**KIRKLEES METROPOLITAN COUNCIL
INVESTMENT & REGENERATION SERVICE**

**DELEGATED DECISION TO DETERMINE PLANNING APPLICATIONS TO
CARRY OUT DEVELOPMENT WITHOUT COMPLIANCE WITH PLANNING
CONDITIONS PREVIOUSLY ATTACHED**

Reference No:	2024/70/93591/E
Site Address:	Hill Crest, The Village, Thurstonland, Huddersfield, HD4 6XX
Description:	Variation condition 2 on previous permission 2023/93683 for erection of first floor extension with front porch, rear dormers and associated internal and external alterations (within a Conservation Area).
Recommending Officer:	Edward Cheseldine

2024/93591 - Hill Crest, The Village, Thurstonland, Huddersfield, HD4 6XX

DRAWING DESCRIPTION
PHASE 2 GARAGE ELEVATIONS AND NOTES AS PROPOSED

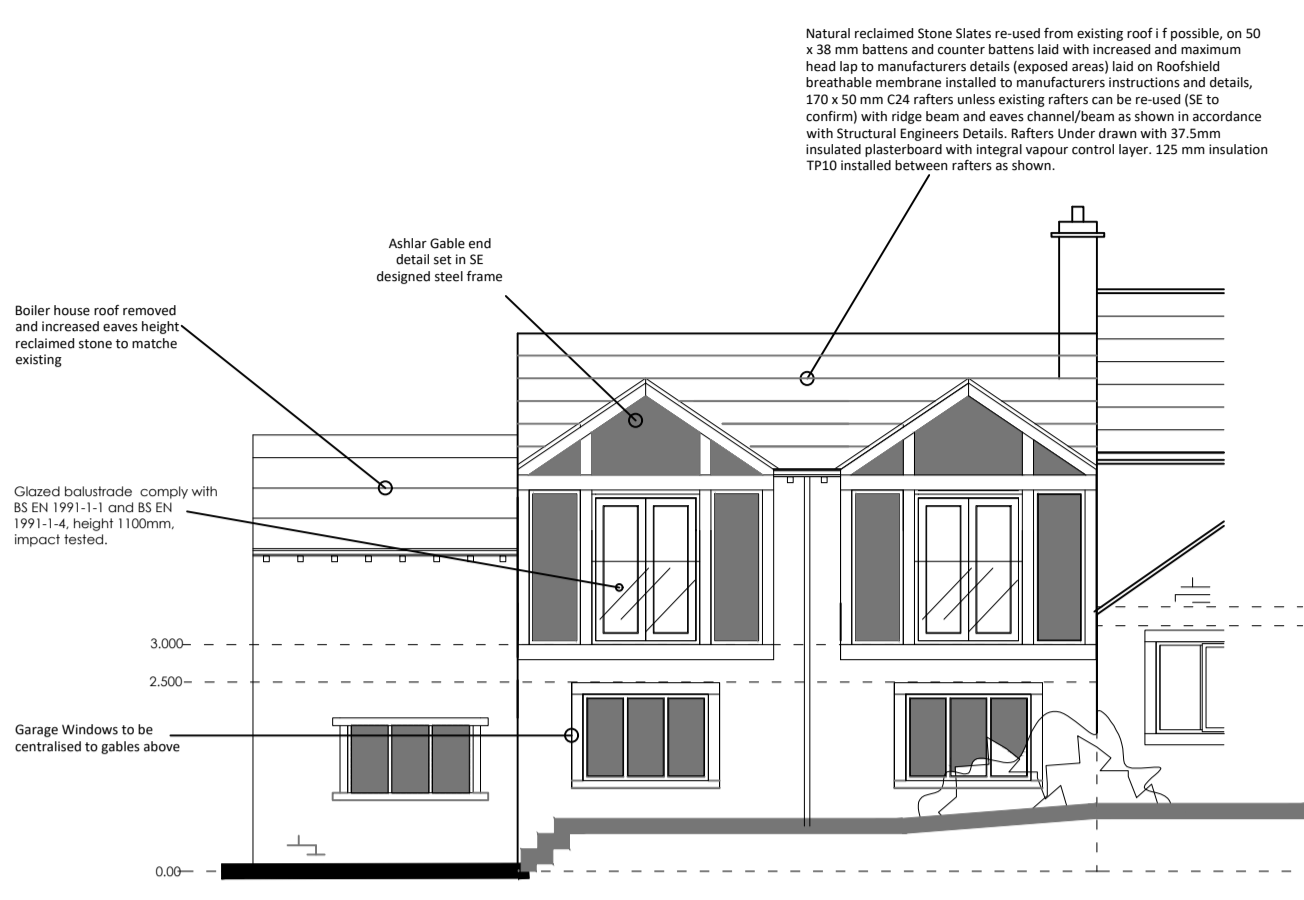
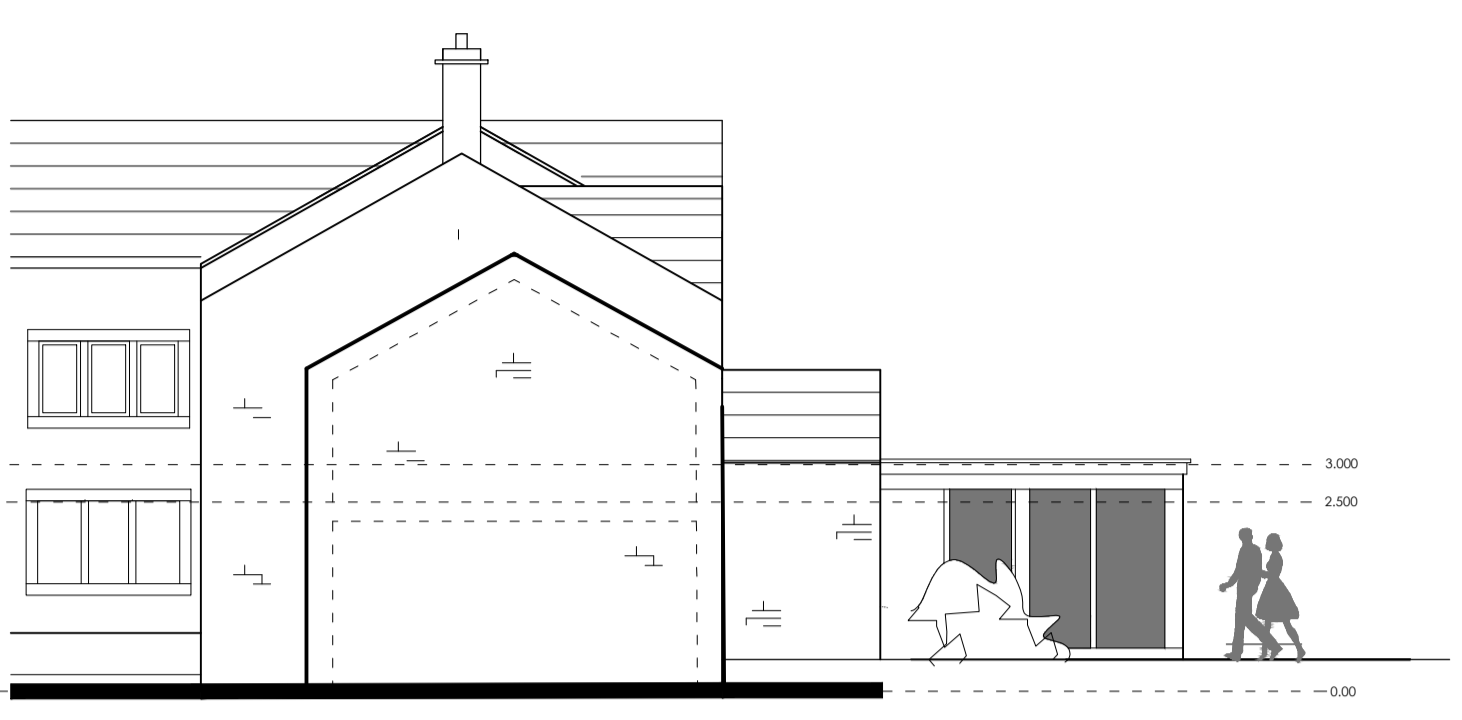
- Removal of gable-end Juliet balconies on the rear elevation to be replaced by mullion windows.
- The eaves height of the northern aspect of the building will be increased to ~4.10m. The roof shape will be changed to a pitched roof.
- Removal of a front doorway and increase the size of the garage opening.
- 3 conservation rooflights to be introduced to the front roof plan.

The modification to the approved plans will remove the gable-end, pitched fenestration. The feature is not present from the public domain, however, the design alterations will simplify the design of the extension and is considered a positive enhancement.

Present on the front elevation will be the increase in roof height of the ground floor projection. This section is set down and back from its adjacent side section, therefore appearing proportionate. The distance between the protrusion and the listed building will not be reduced as the changes relate to height. The roof section will also be altered to host a pitched roof. Such a change will not change the overall appearance of the building, given there are existing pitched roofs. Conservation rooflight will be placed set into the front roofplane, which are sensitive in terms of size and appearance.

The existing garage opening will be extended, by 1.60m. The alteration is modest. The wood details to the front will be retained.

In terms of the above, the changes to the side projection accords with the guidance outlined within the House Extensions & Alterations Supplementary Planning Document. It is set down and back from the adjacent side projection therefore appearing subservient. The roof form continues the pitched roof of the main dwelling. A 1 metre gap to the side will be retained.

New windows are high level and will not have view towards neighbouring habitable rooms. The new windows to the rear were previously assessed on 2023/93683 and will not have an impact to privacy. Due to distance, there will not be a loss of outlook, loss of light or an overbearing impact to neighbouring occupants.

5. Unless otherwise agreed in writing by the Local Planning Authority, the roof windows shall be Velux Conservation Roof Windows, model CC04, with recessed flashing kit and central glazing bar and thereafter retained as such.
